Response to Comments

Project Name: 163 RV Technical Review 1
 Project File Number: PA 23016
 Review Completion: October 2, 2023

SU-40 Single Unit Track

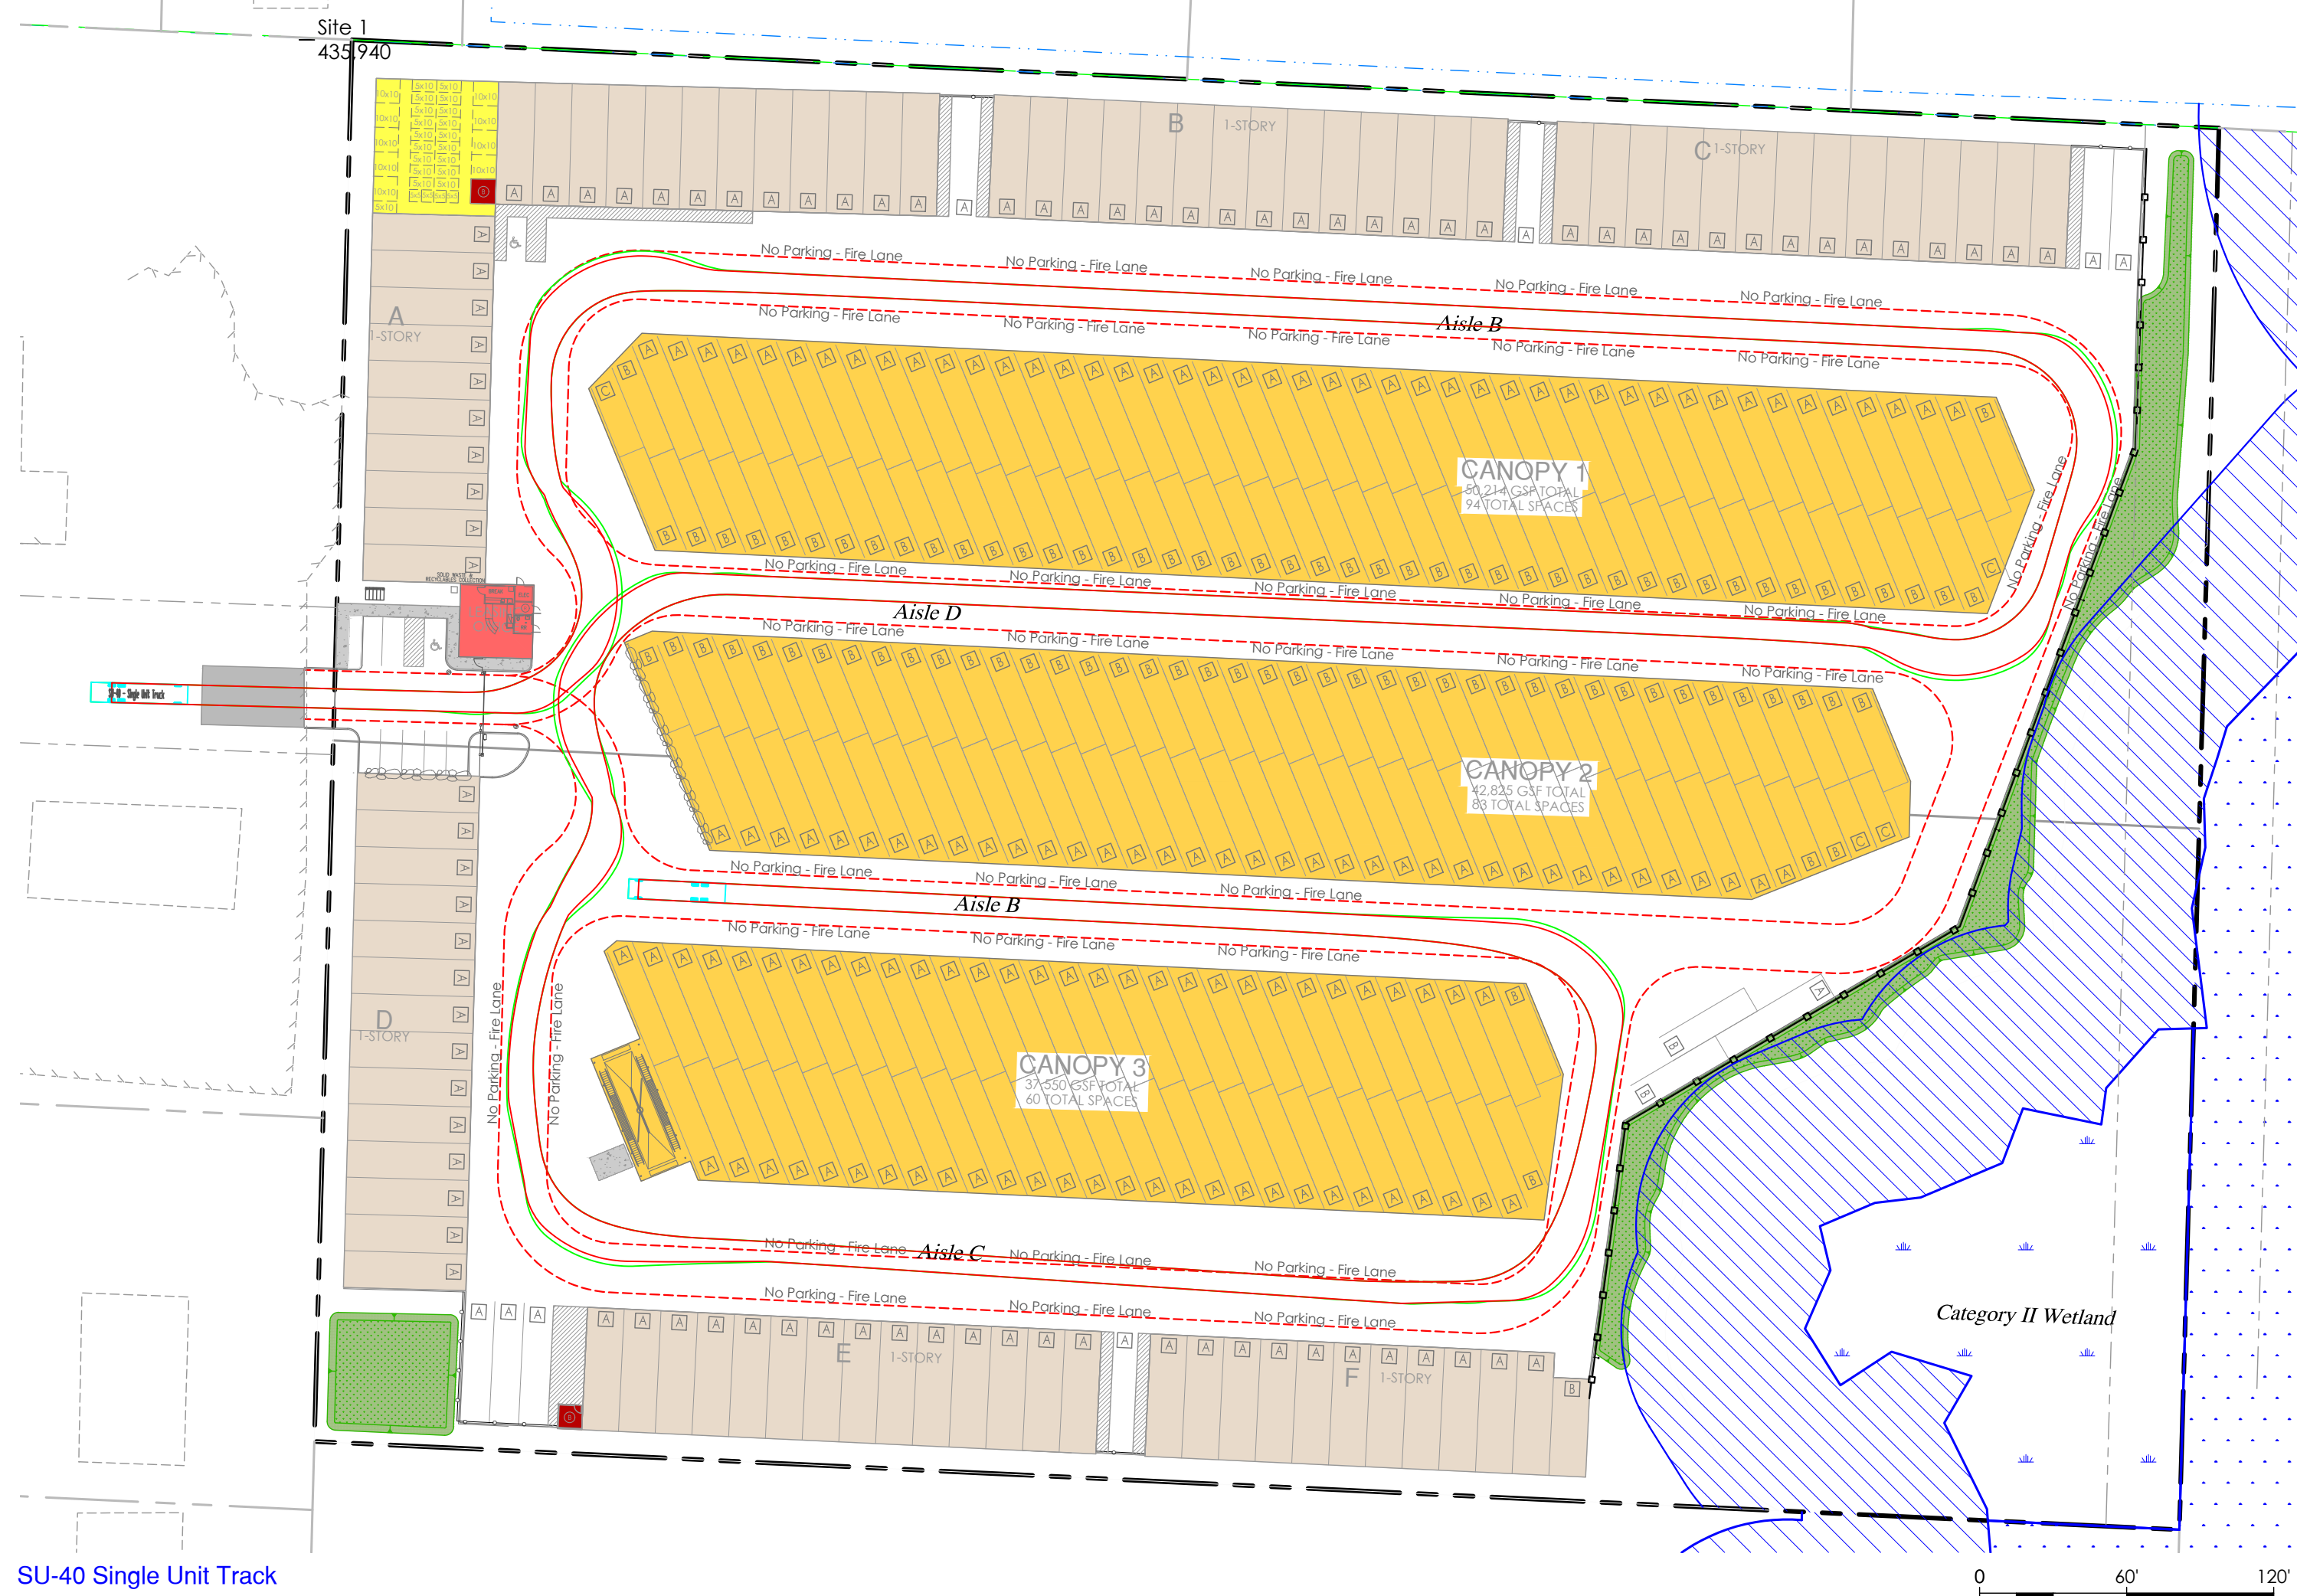
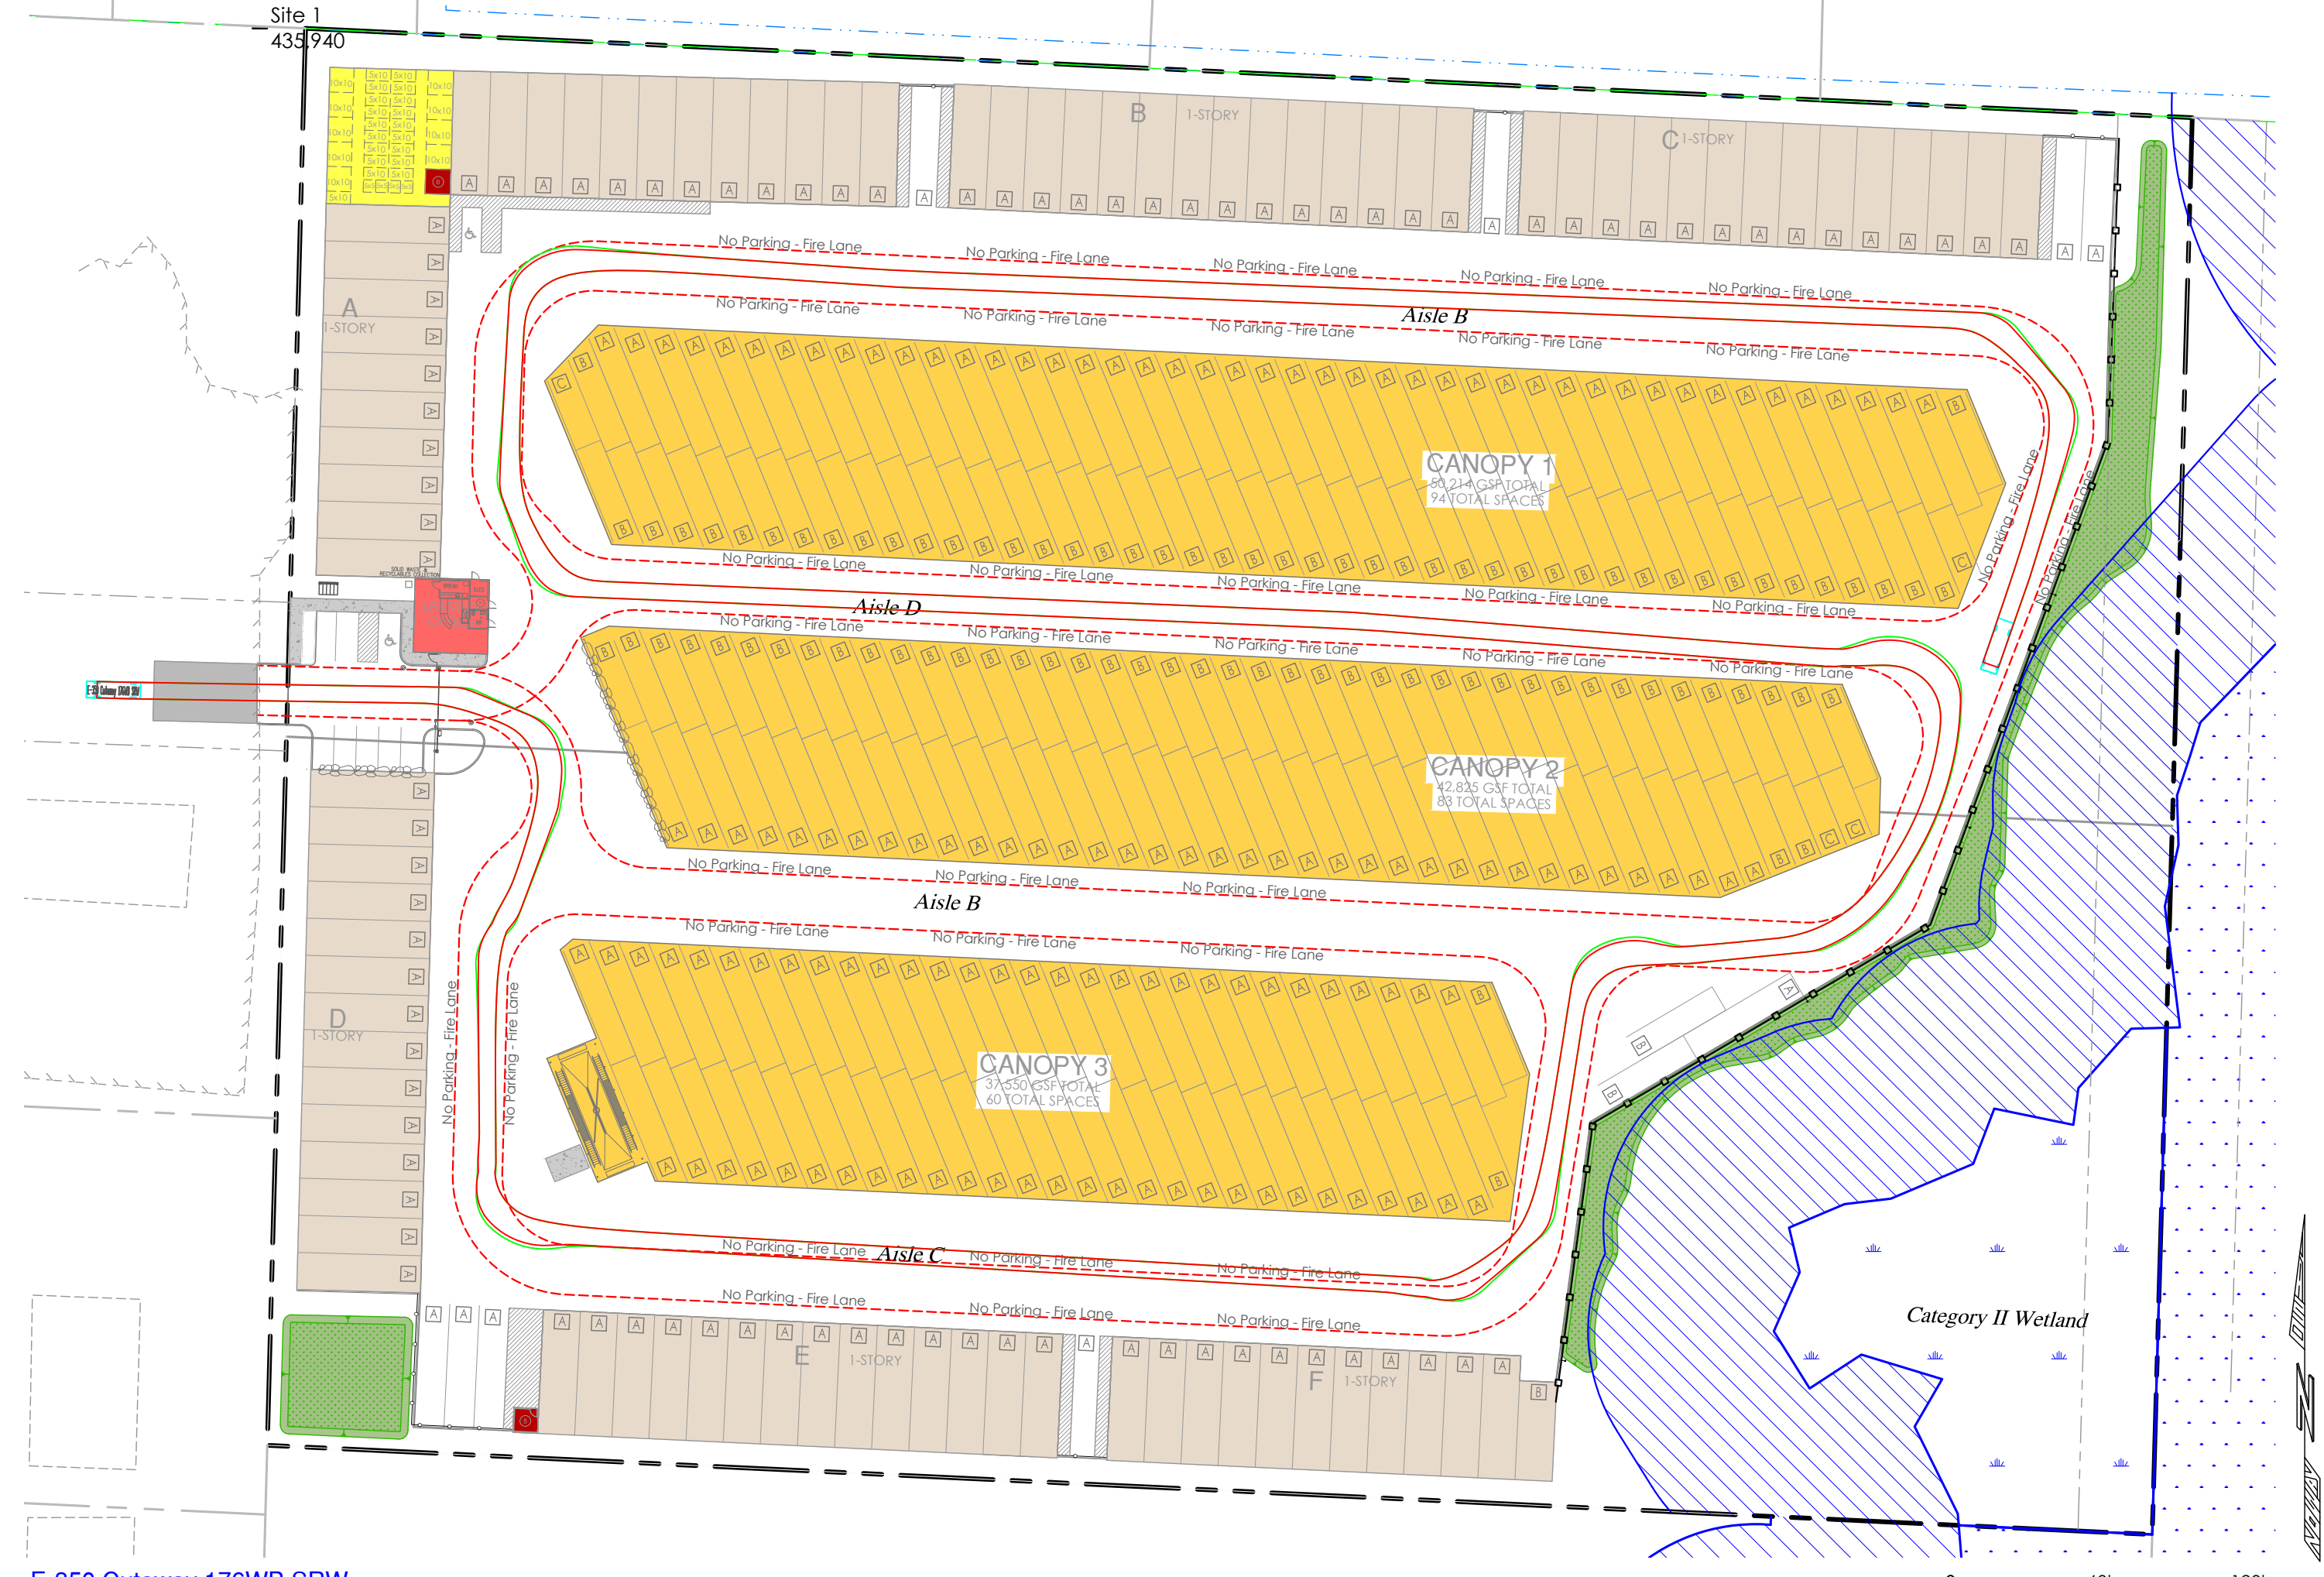
CITY COMMENTS	LAND TECH RESPONSE
<p>f. Provide the location for solid waste and recyclables collection. Contact Kristy Beedle, Solid Waste Supervisor, 360.36.8152 kbeedle@marysvillewa.gov, for enclosure size and design requirements.</p> <p>g. Provide an auto-turn exhibit demonstrating the Emergency Service vehicles, RV's, trucks and trailers can navigate through the site.</p>	<p>A Trash Service Area has been designated in Building A near the office. It will be enclosed in the building envelope and accessed via a roll-up door facing the customer parking</p> <p>C20 AutoTurn – Vehicle Tracking plan has been added to the plan set.</p>
<p>7. The landscape plan shall be amended, as follows:</p> <p>a. Street trees shall be required to be planted at a rate of 1 per 30 feet of frontage along the access drive from the proposed development to Smokey Point Boulevard, and comply with the following:</p> <p>i. Street trees shall be planted 5 to 8 ft. behind the sidewalk to create a continuous canopy.</p> <p>ii. Street trees shall meet the most recent ANSI standards for a 1 VV' caliper at the time of planting and shall be spaced to provide a continuous canopy coverage within 10-years.</p> <p>b. Add location of bike racks and provide detail. The bike racks will need to be</p>	<p>As per earlier arguments, this project cannot build the access road as requested. I am not sure the Street trees should be an element of Commercial Access Roads. In this case, this is primarily a Parking Lot Drive Aisle and should be subject to the Parking Lot Landscape Standards.</p> <p>Any trees at this time would significantly impact the existing uses and this applicant as no right to do that.</p> <p>A bike rack is shown just west of the Leasing Office and is set on a concrete pad.</p>
